CITY OF ALBUQUERQUE

June 7, 2012

**Re: North Town Plaza Restaurant, Grading and Drainage Plan
Engineer's Stamp Date 6/01/2012 (E19/D015)**

GRADING & DRAINAGE PLAN

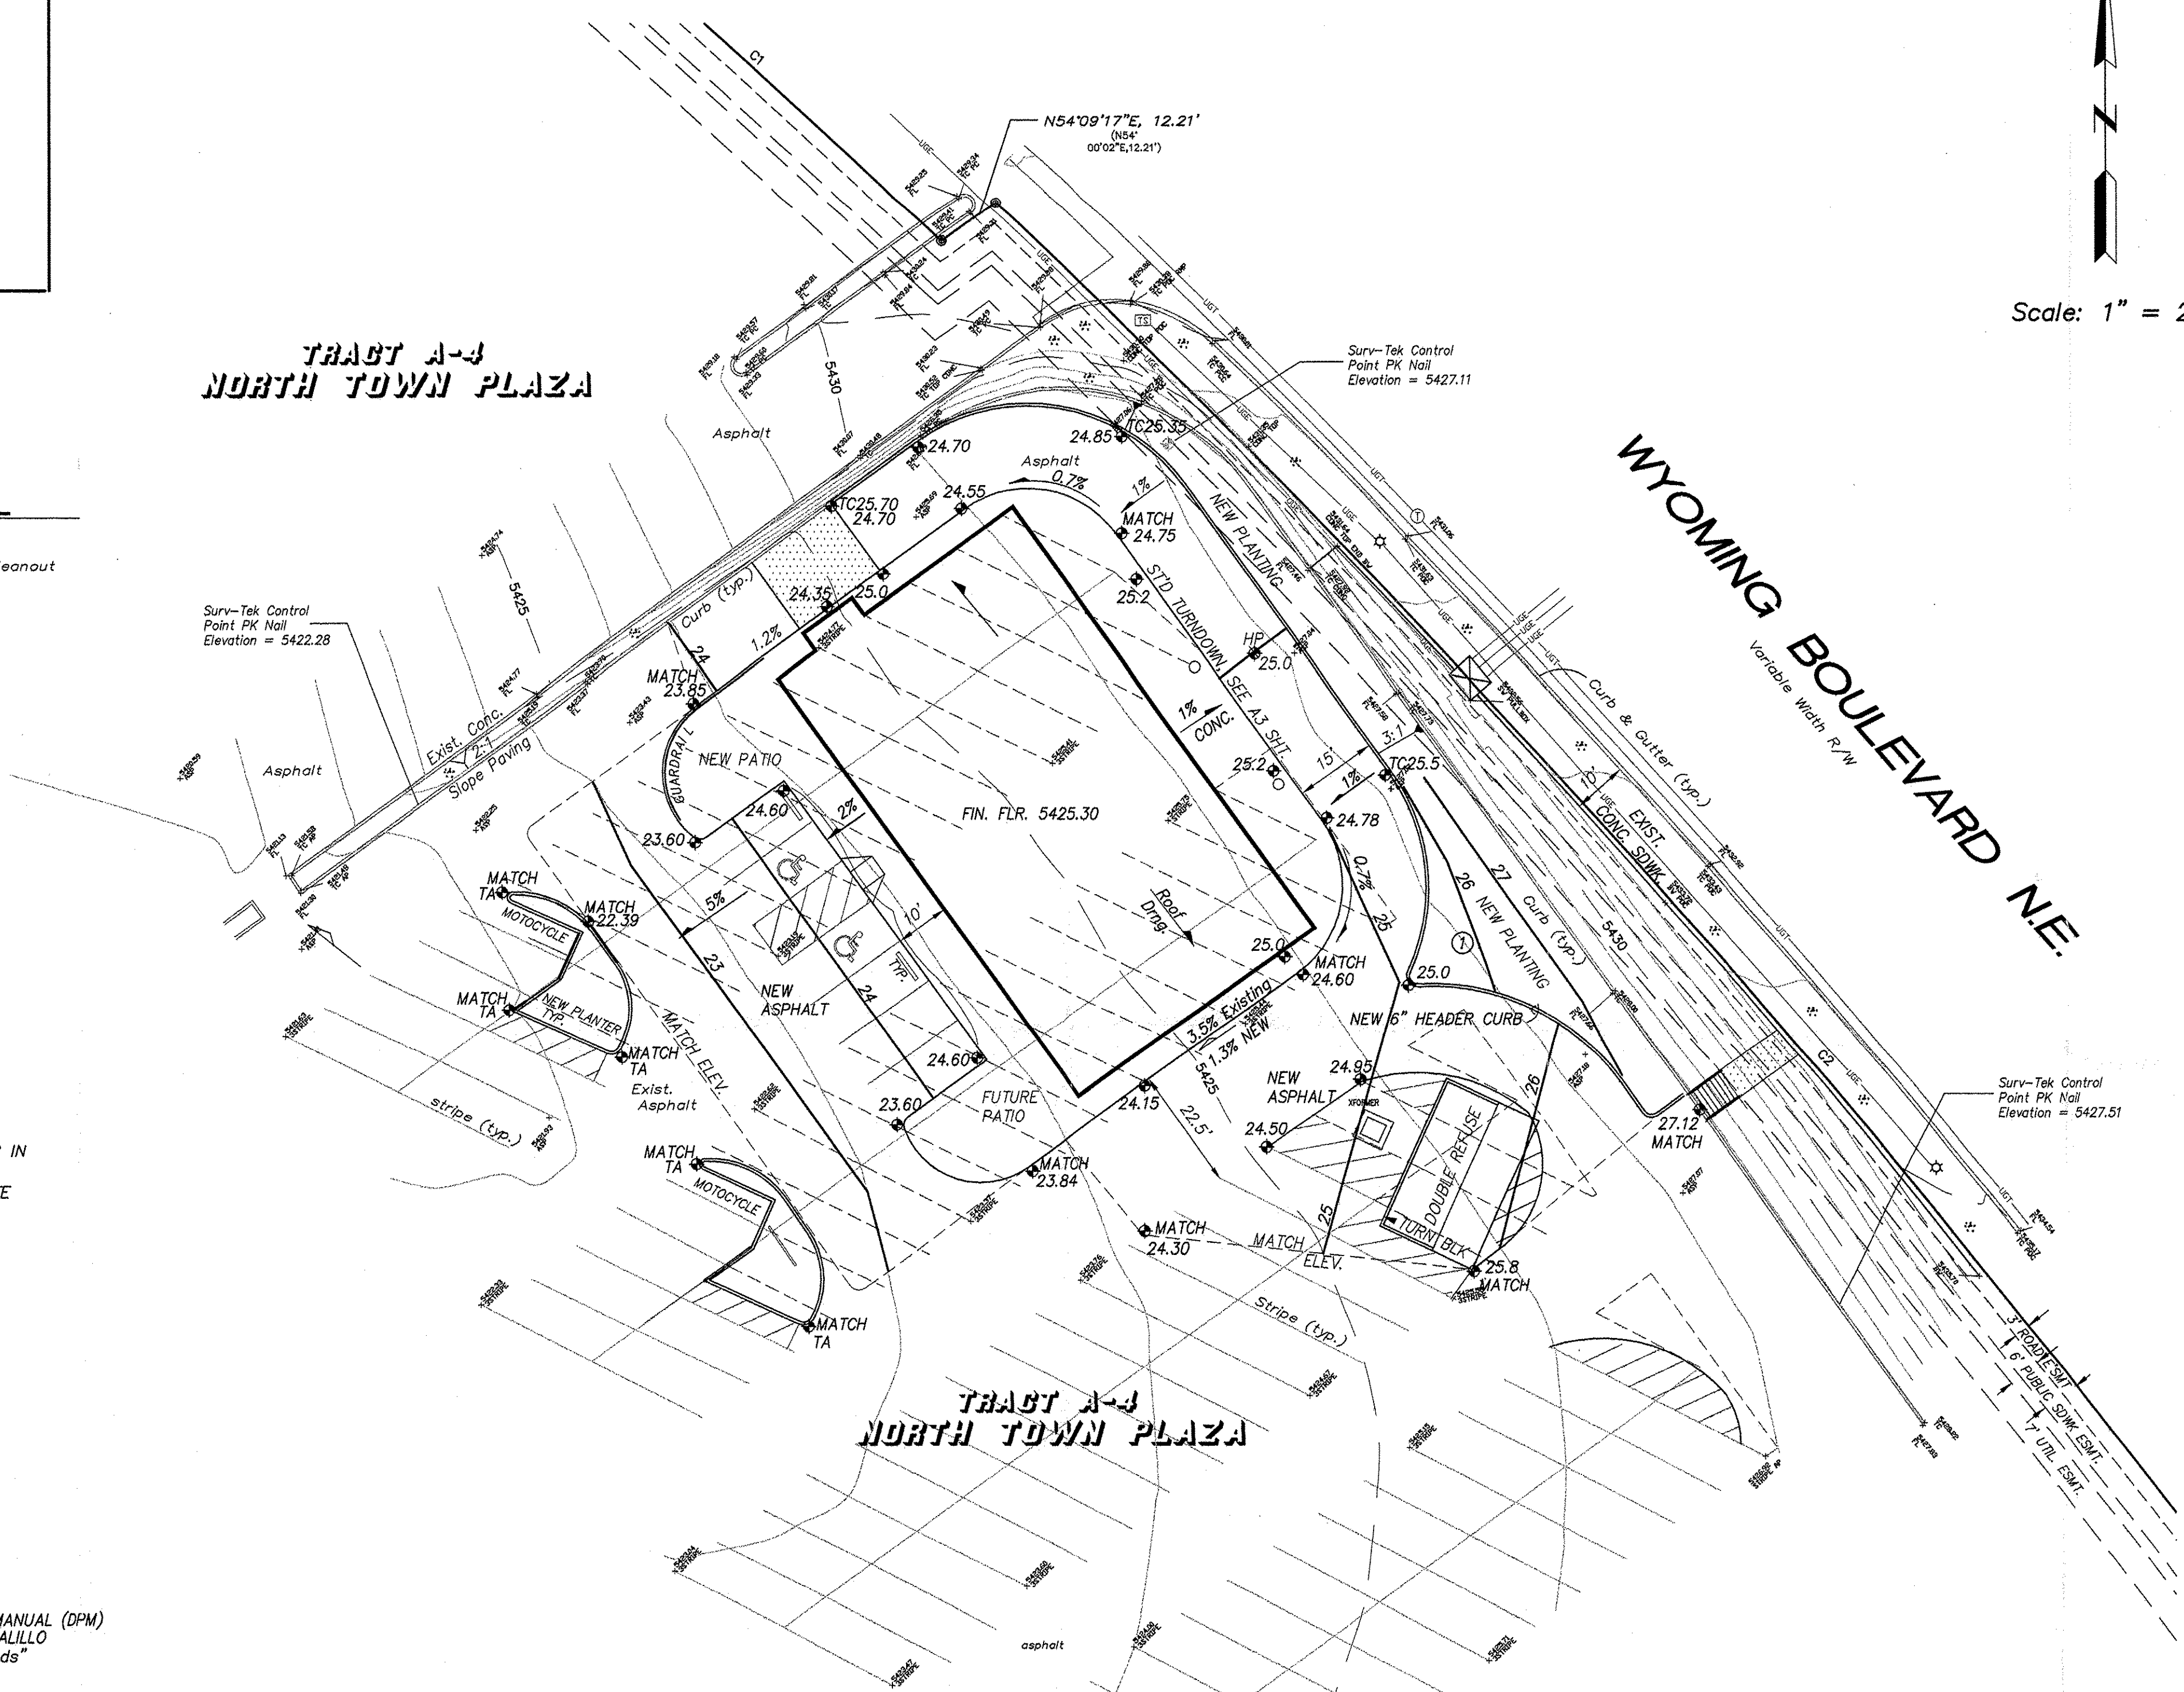
Based upon the information provided in your submittal received 6-01-12, the grading and Drainage Plan is approved for Building Permit. Please double check the proposed top of asphalt elevation on the east side of the building at the high point with elevation at 25.0. The sidewalk/curb height (top of sidewalk/top of curb elevation 25.20') is only 0.20'.
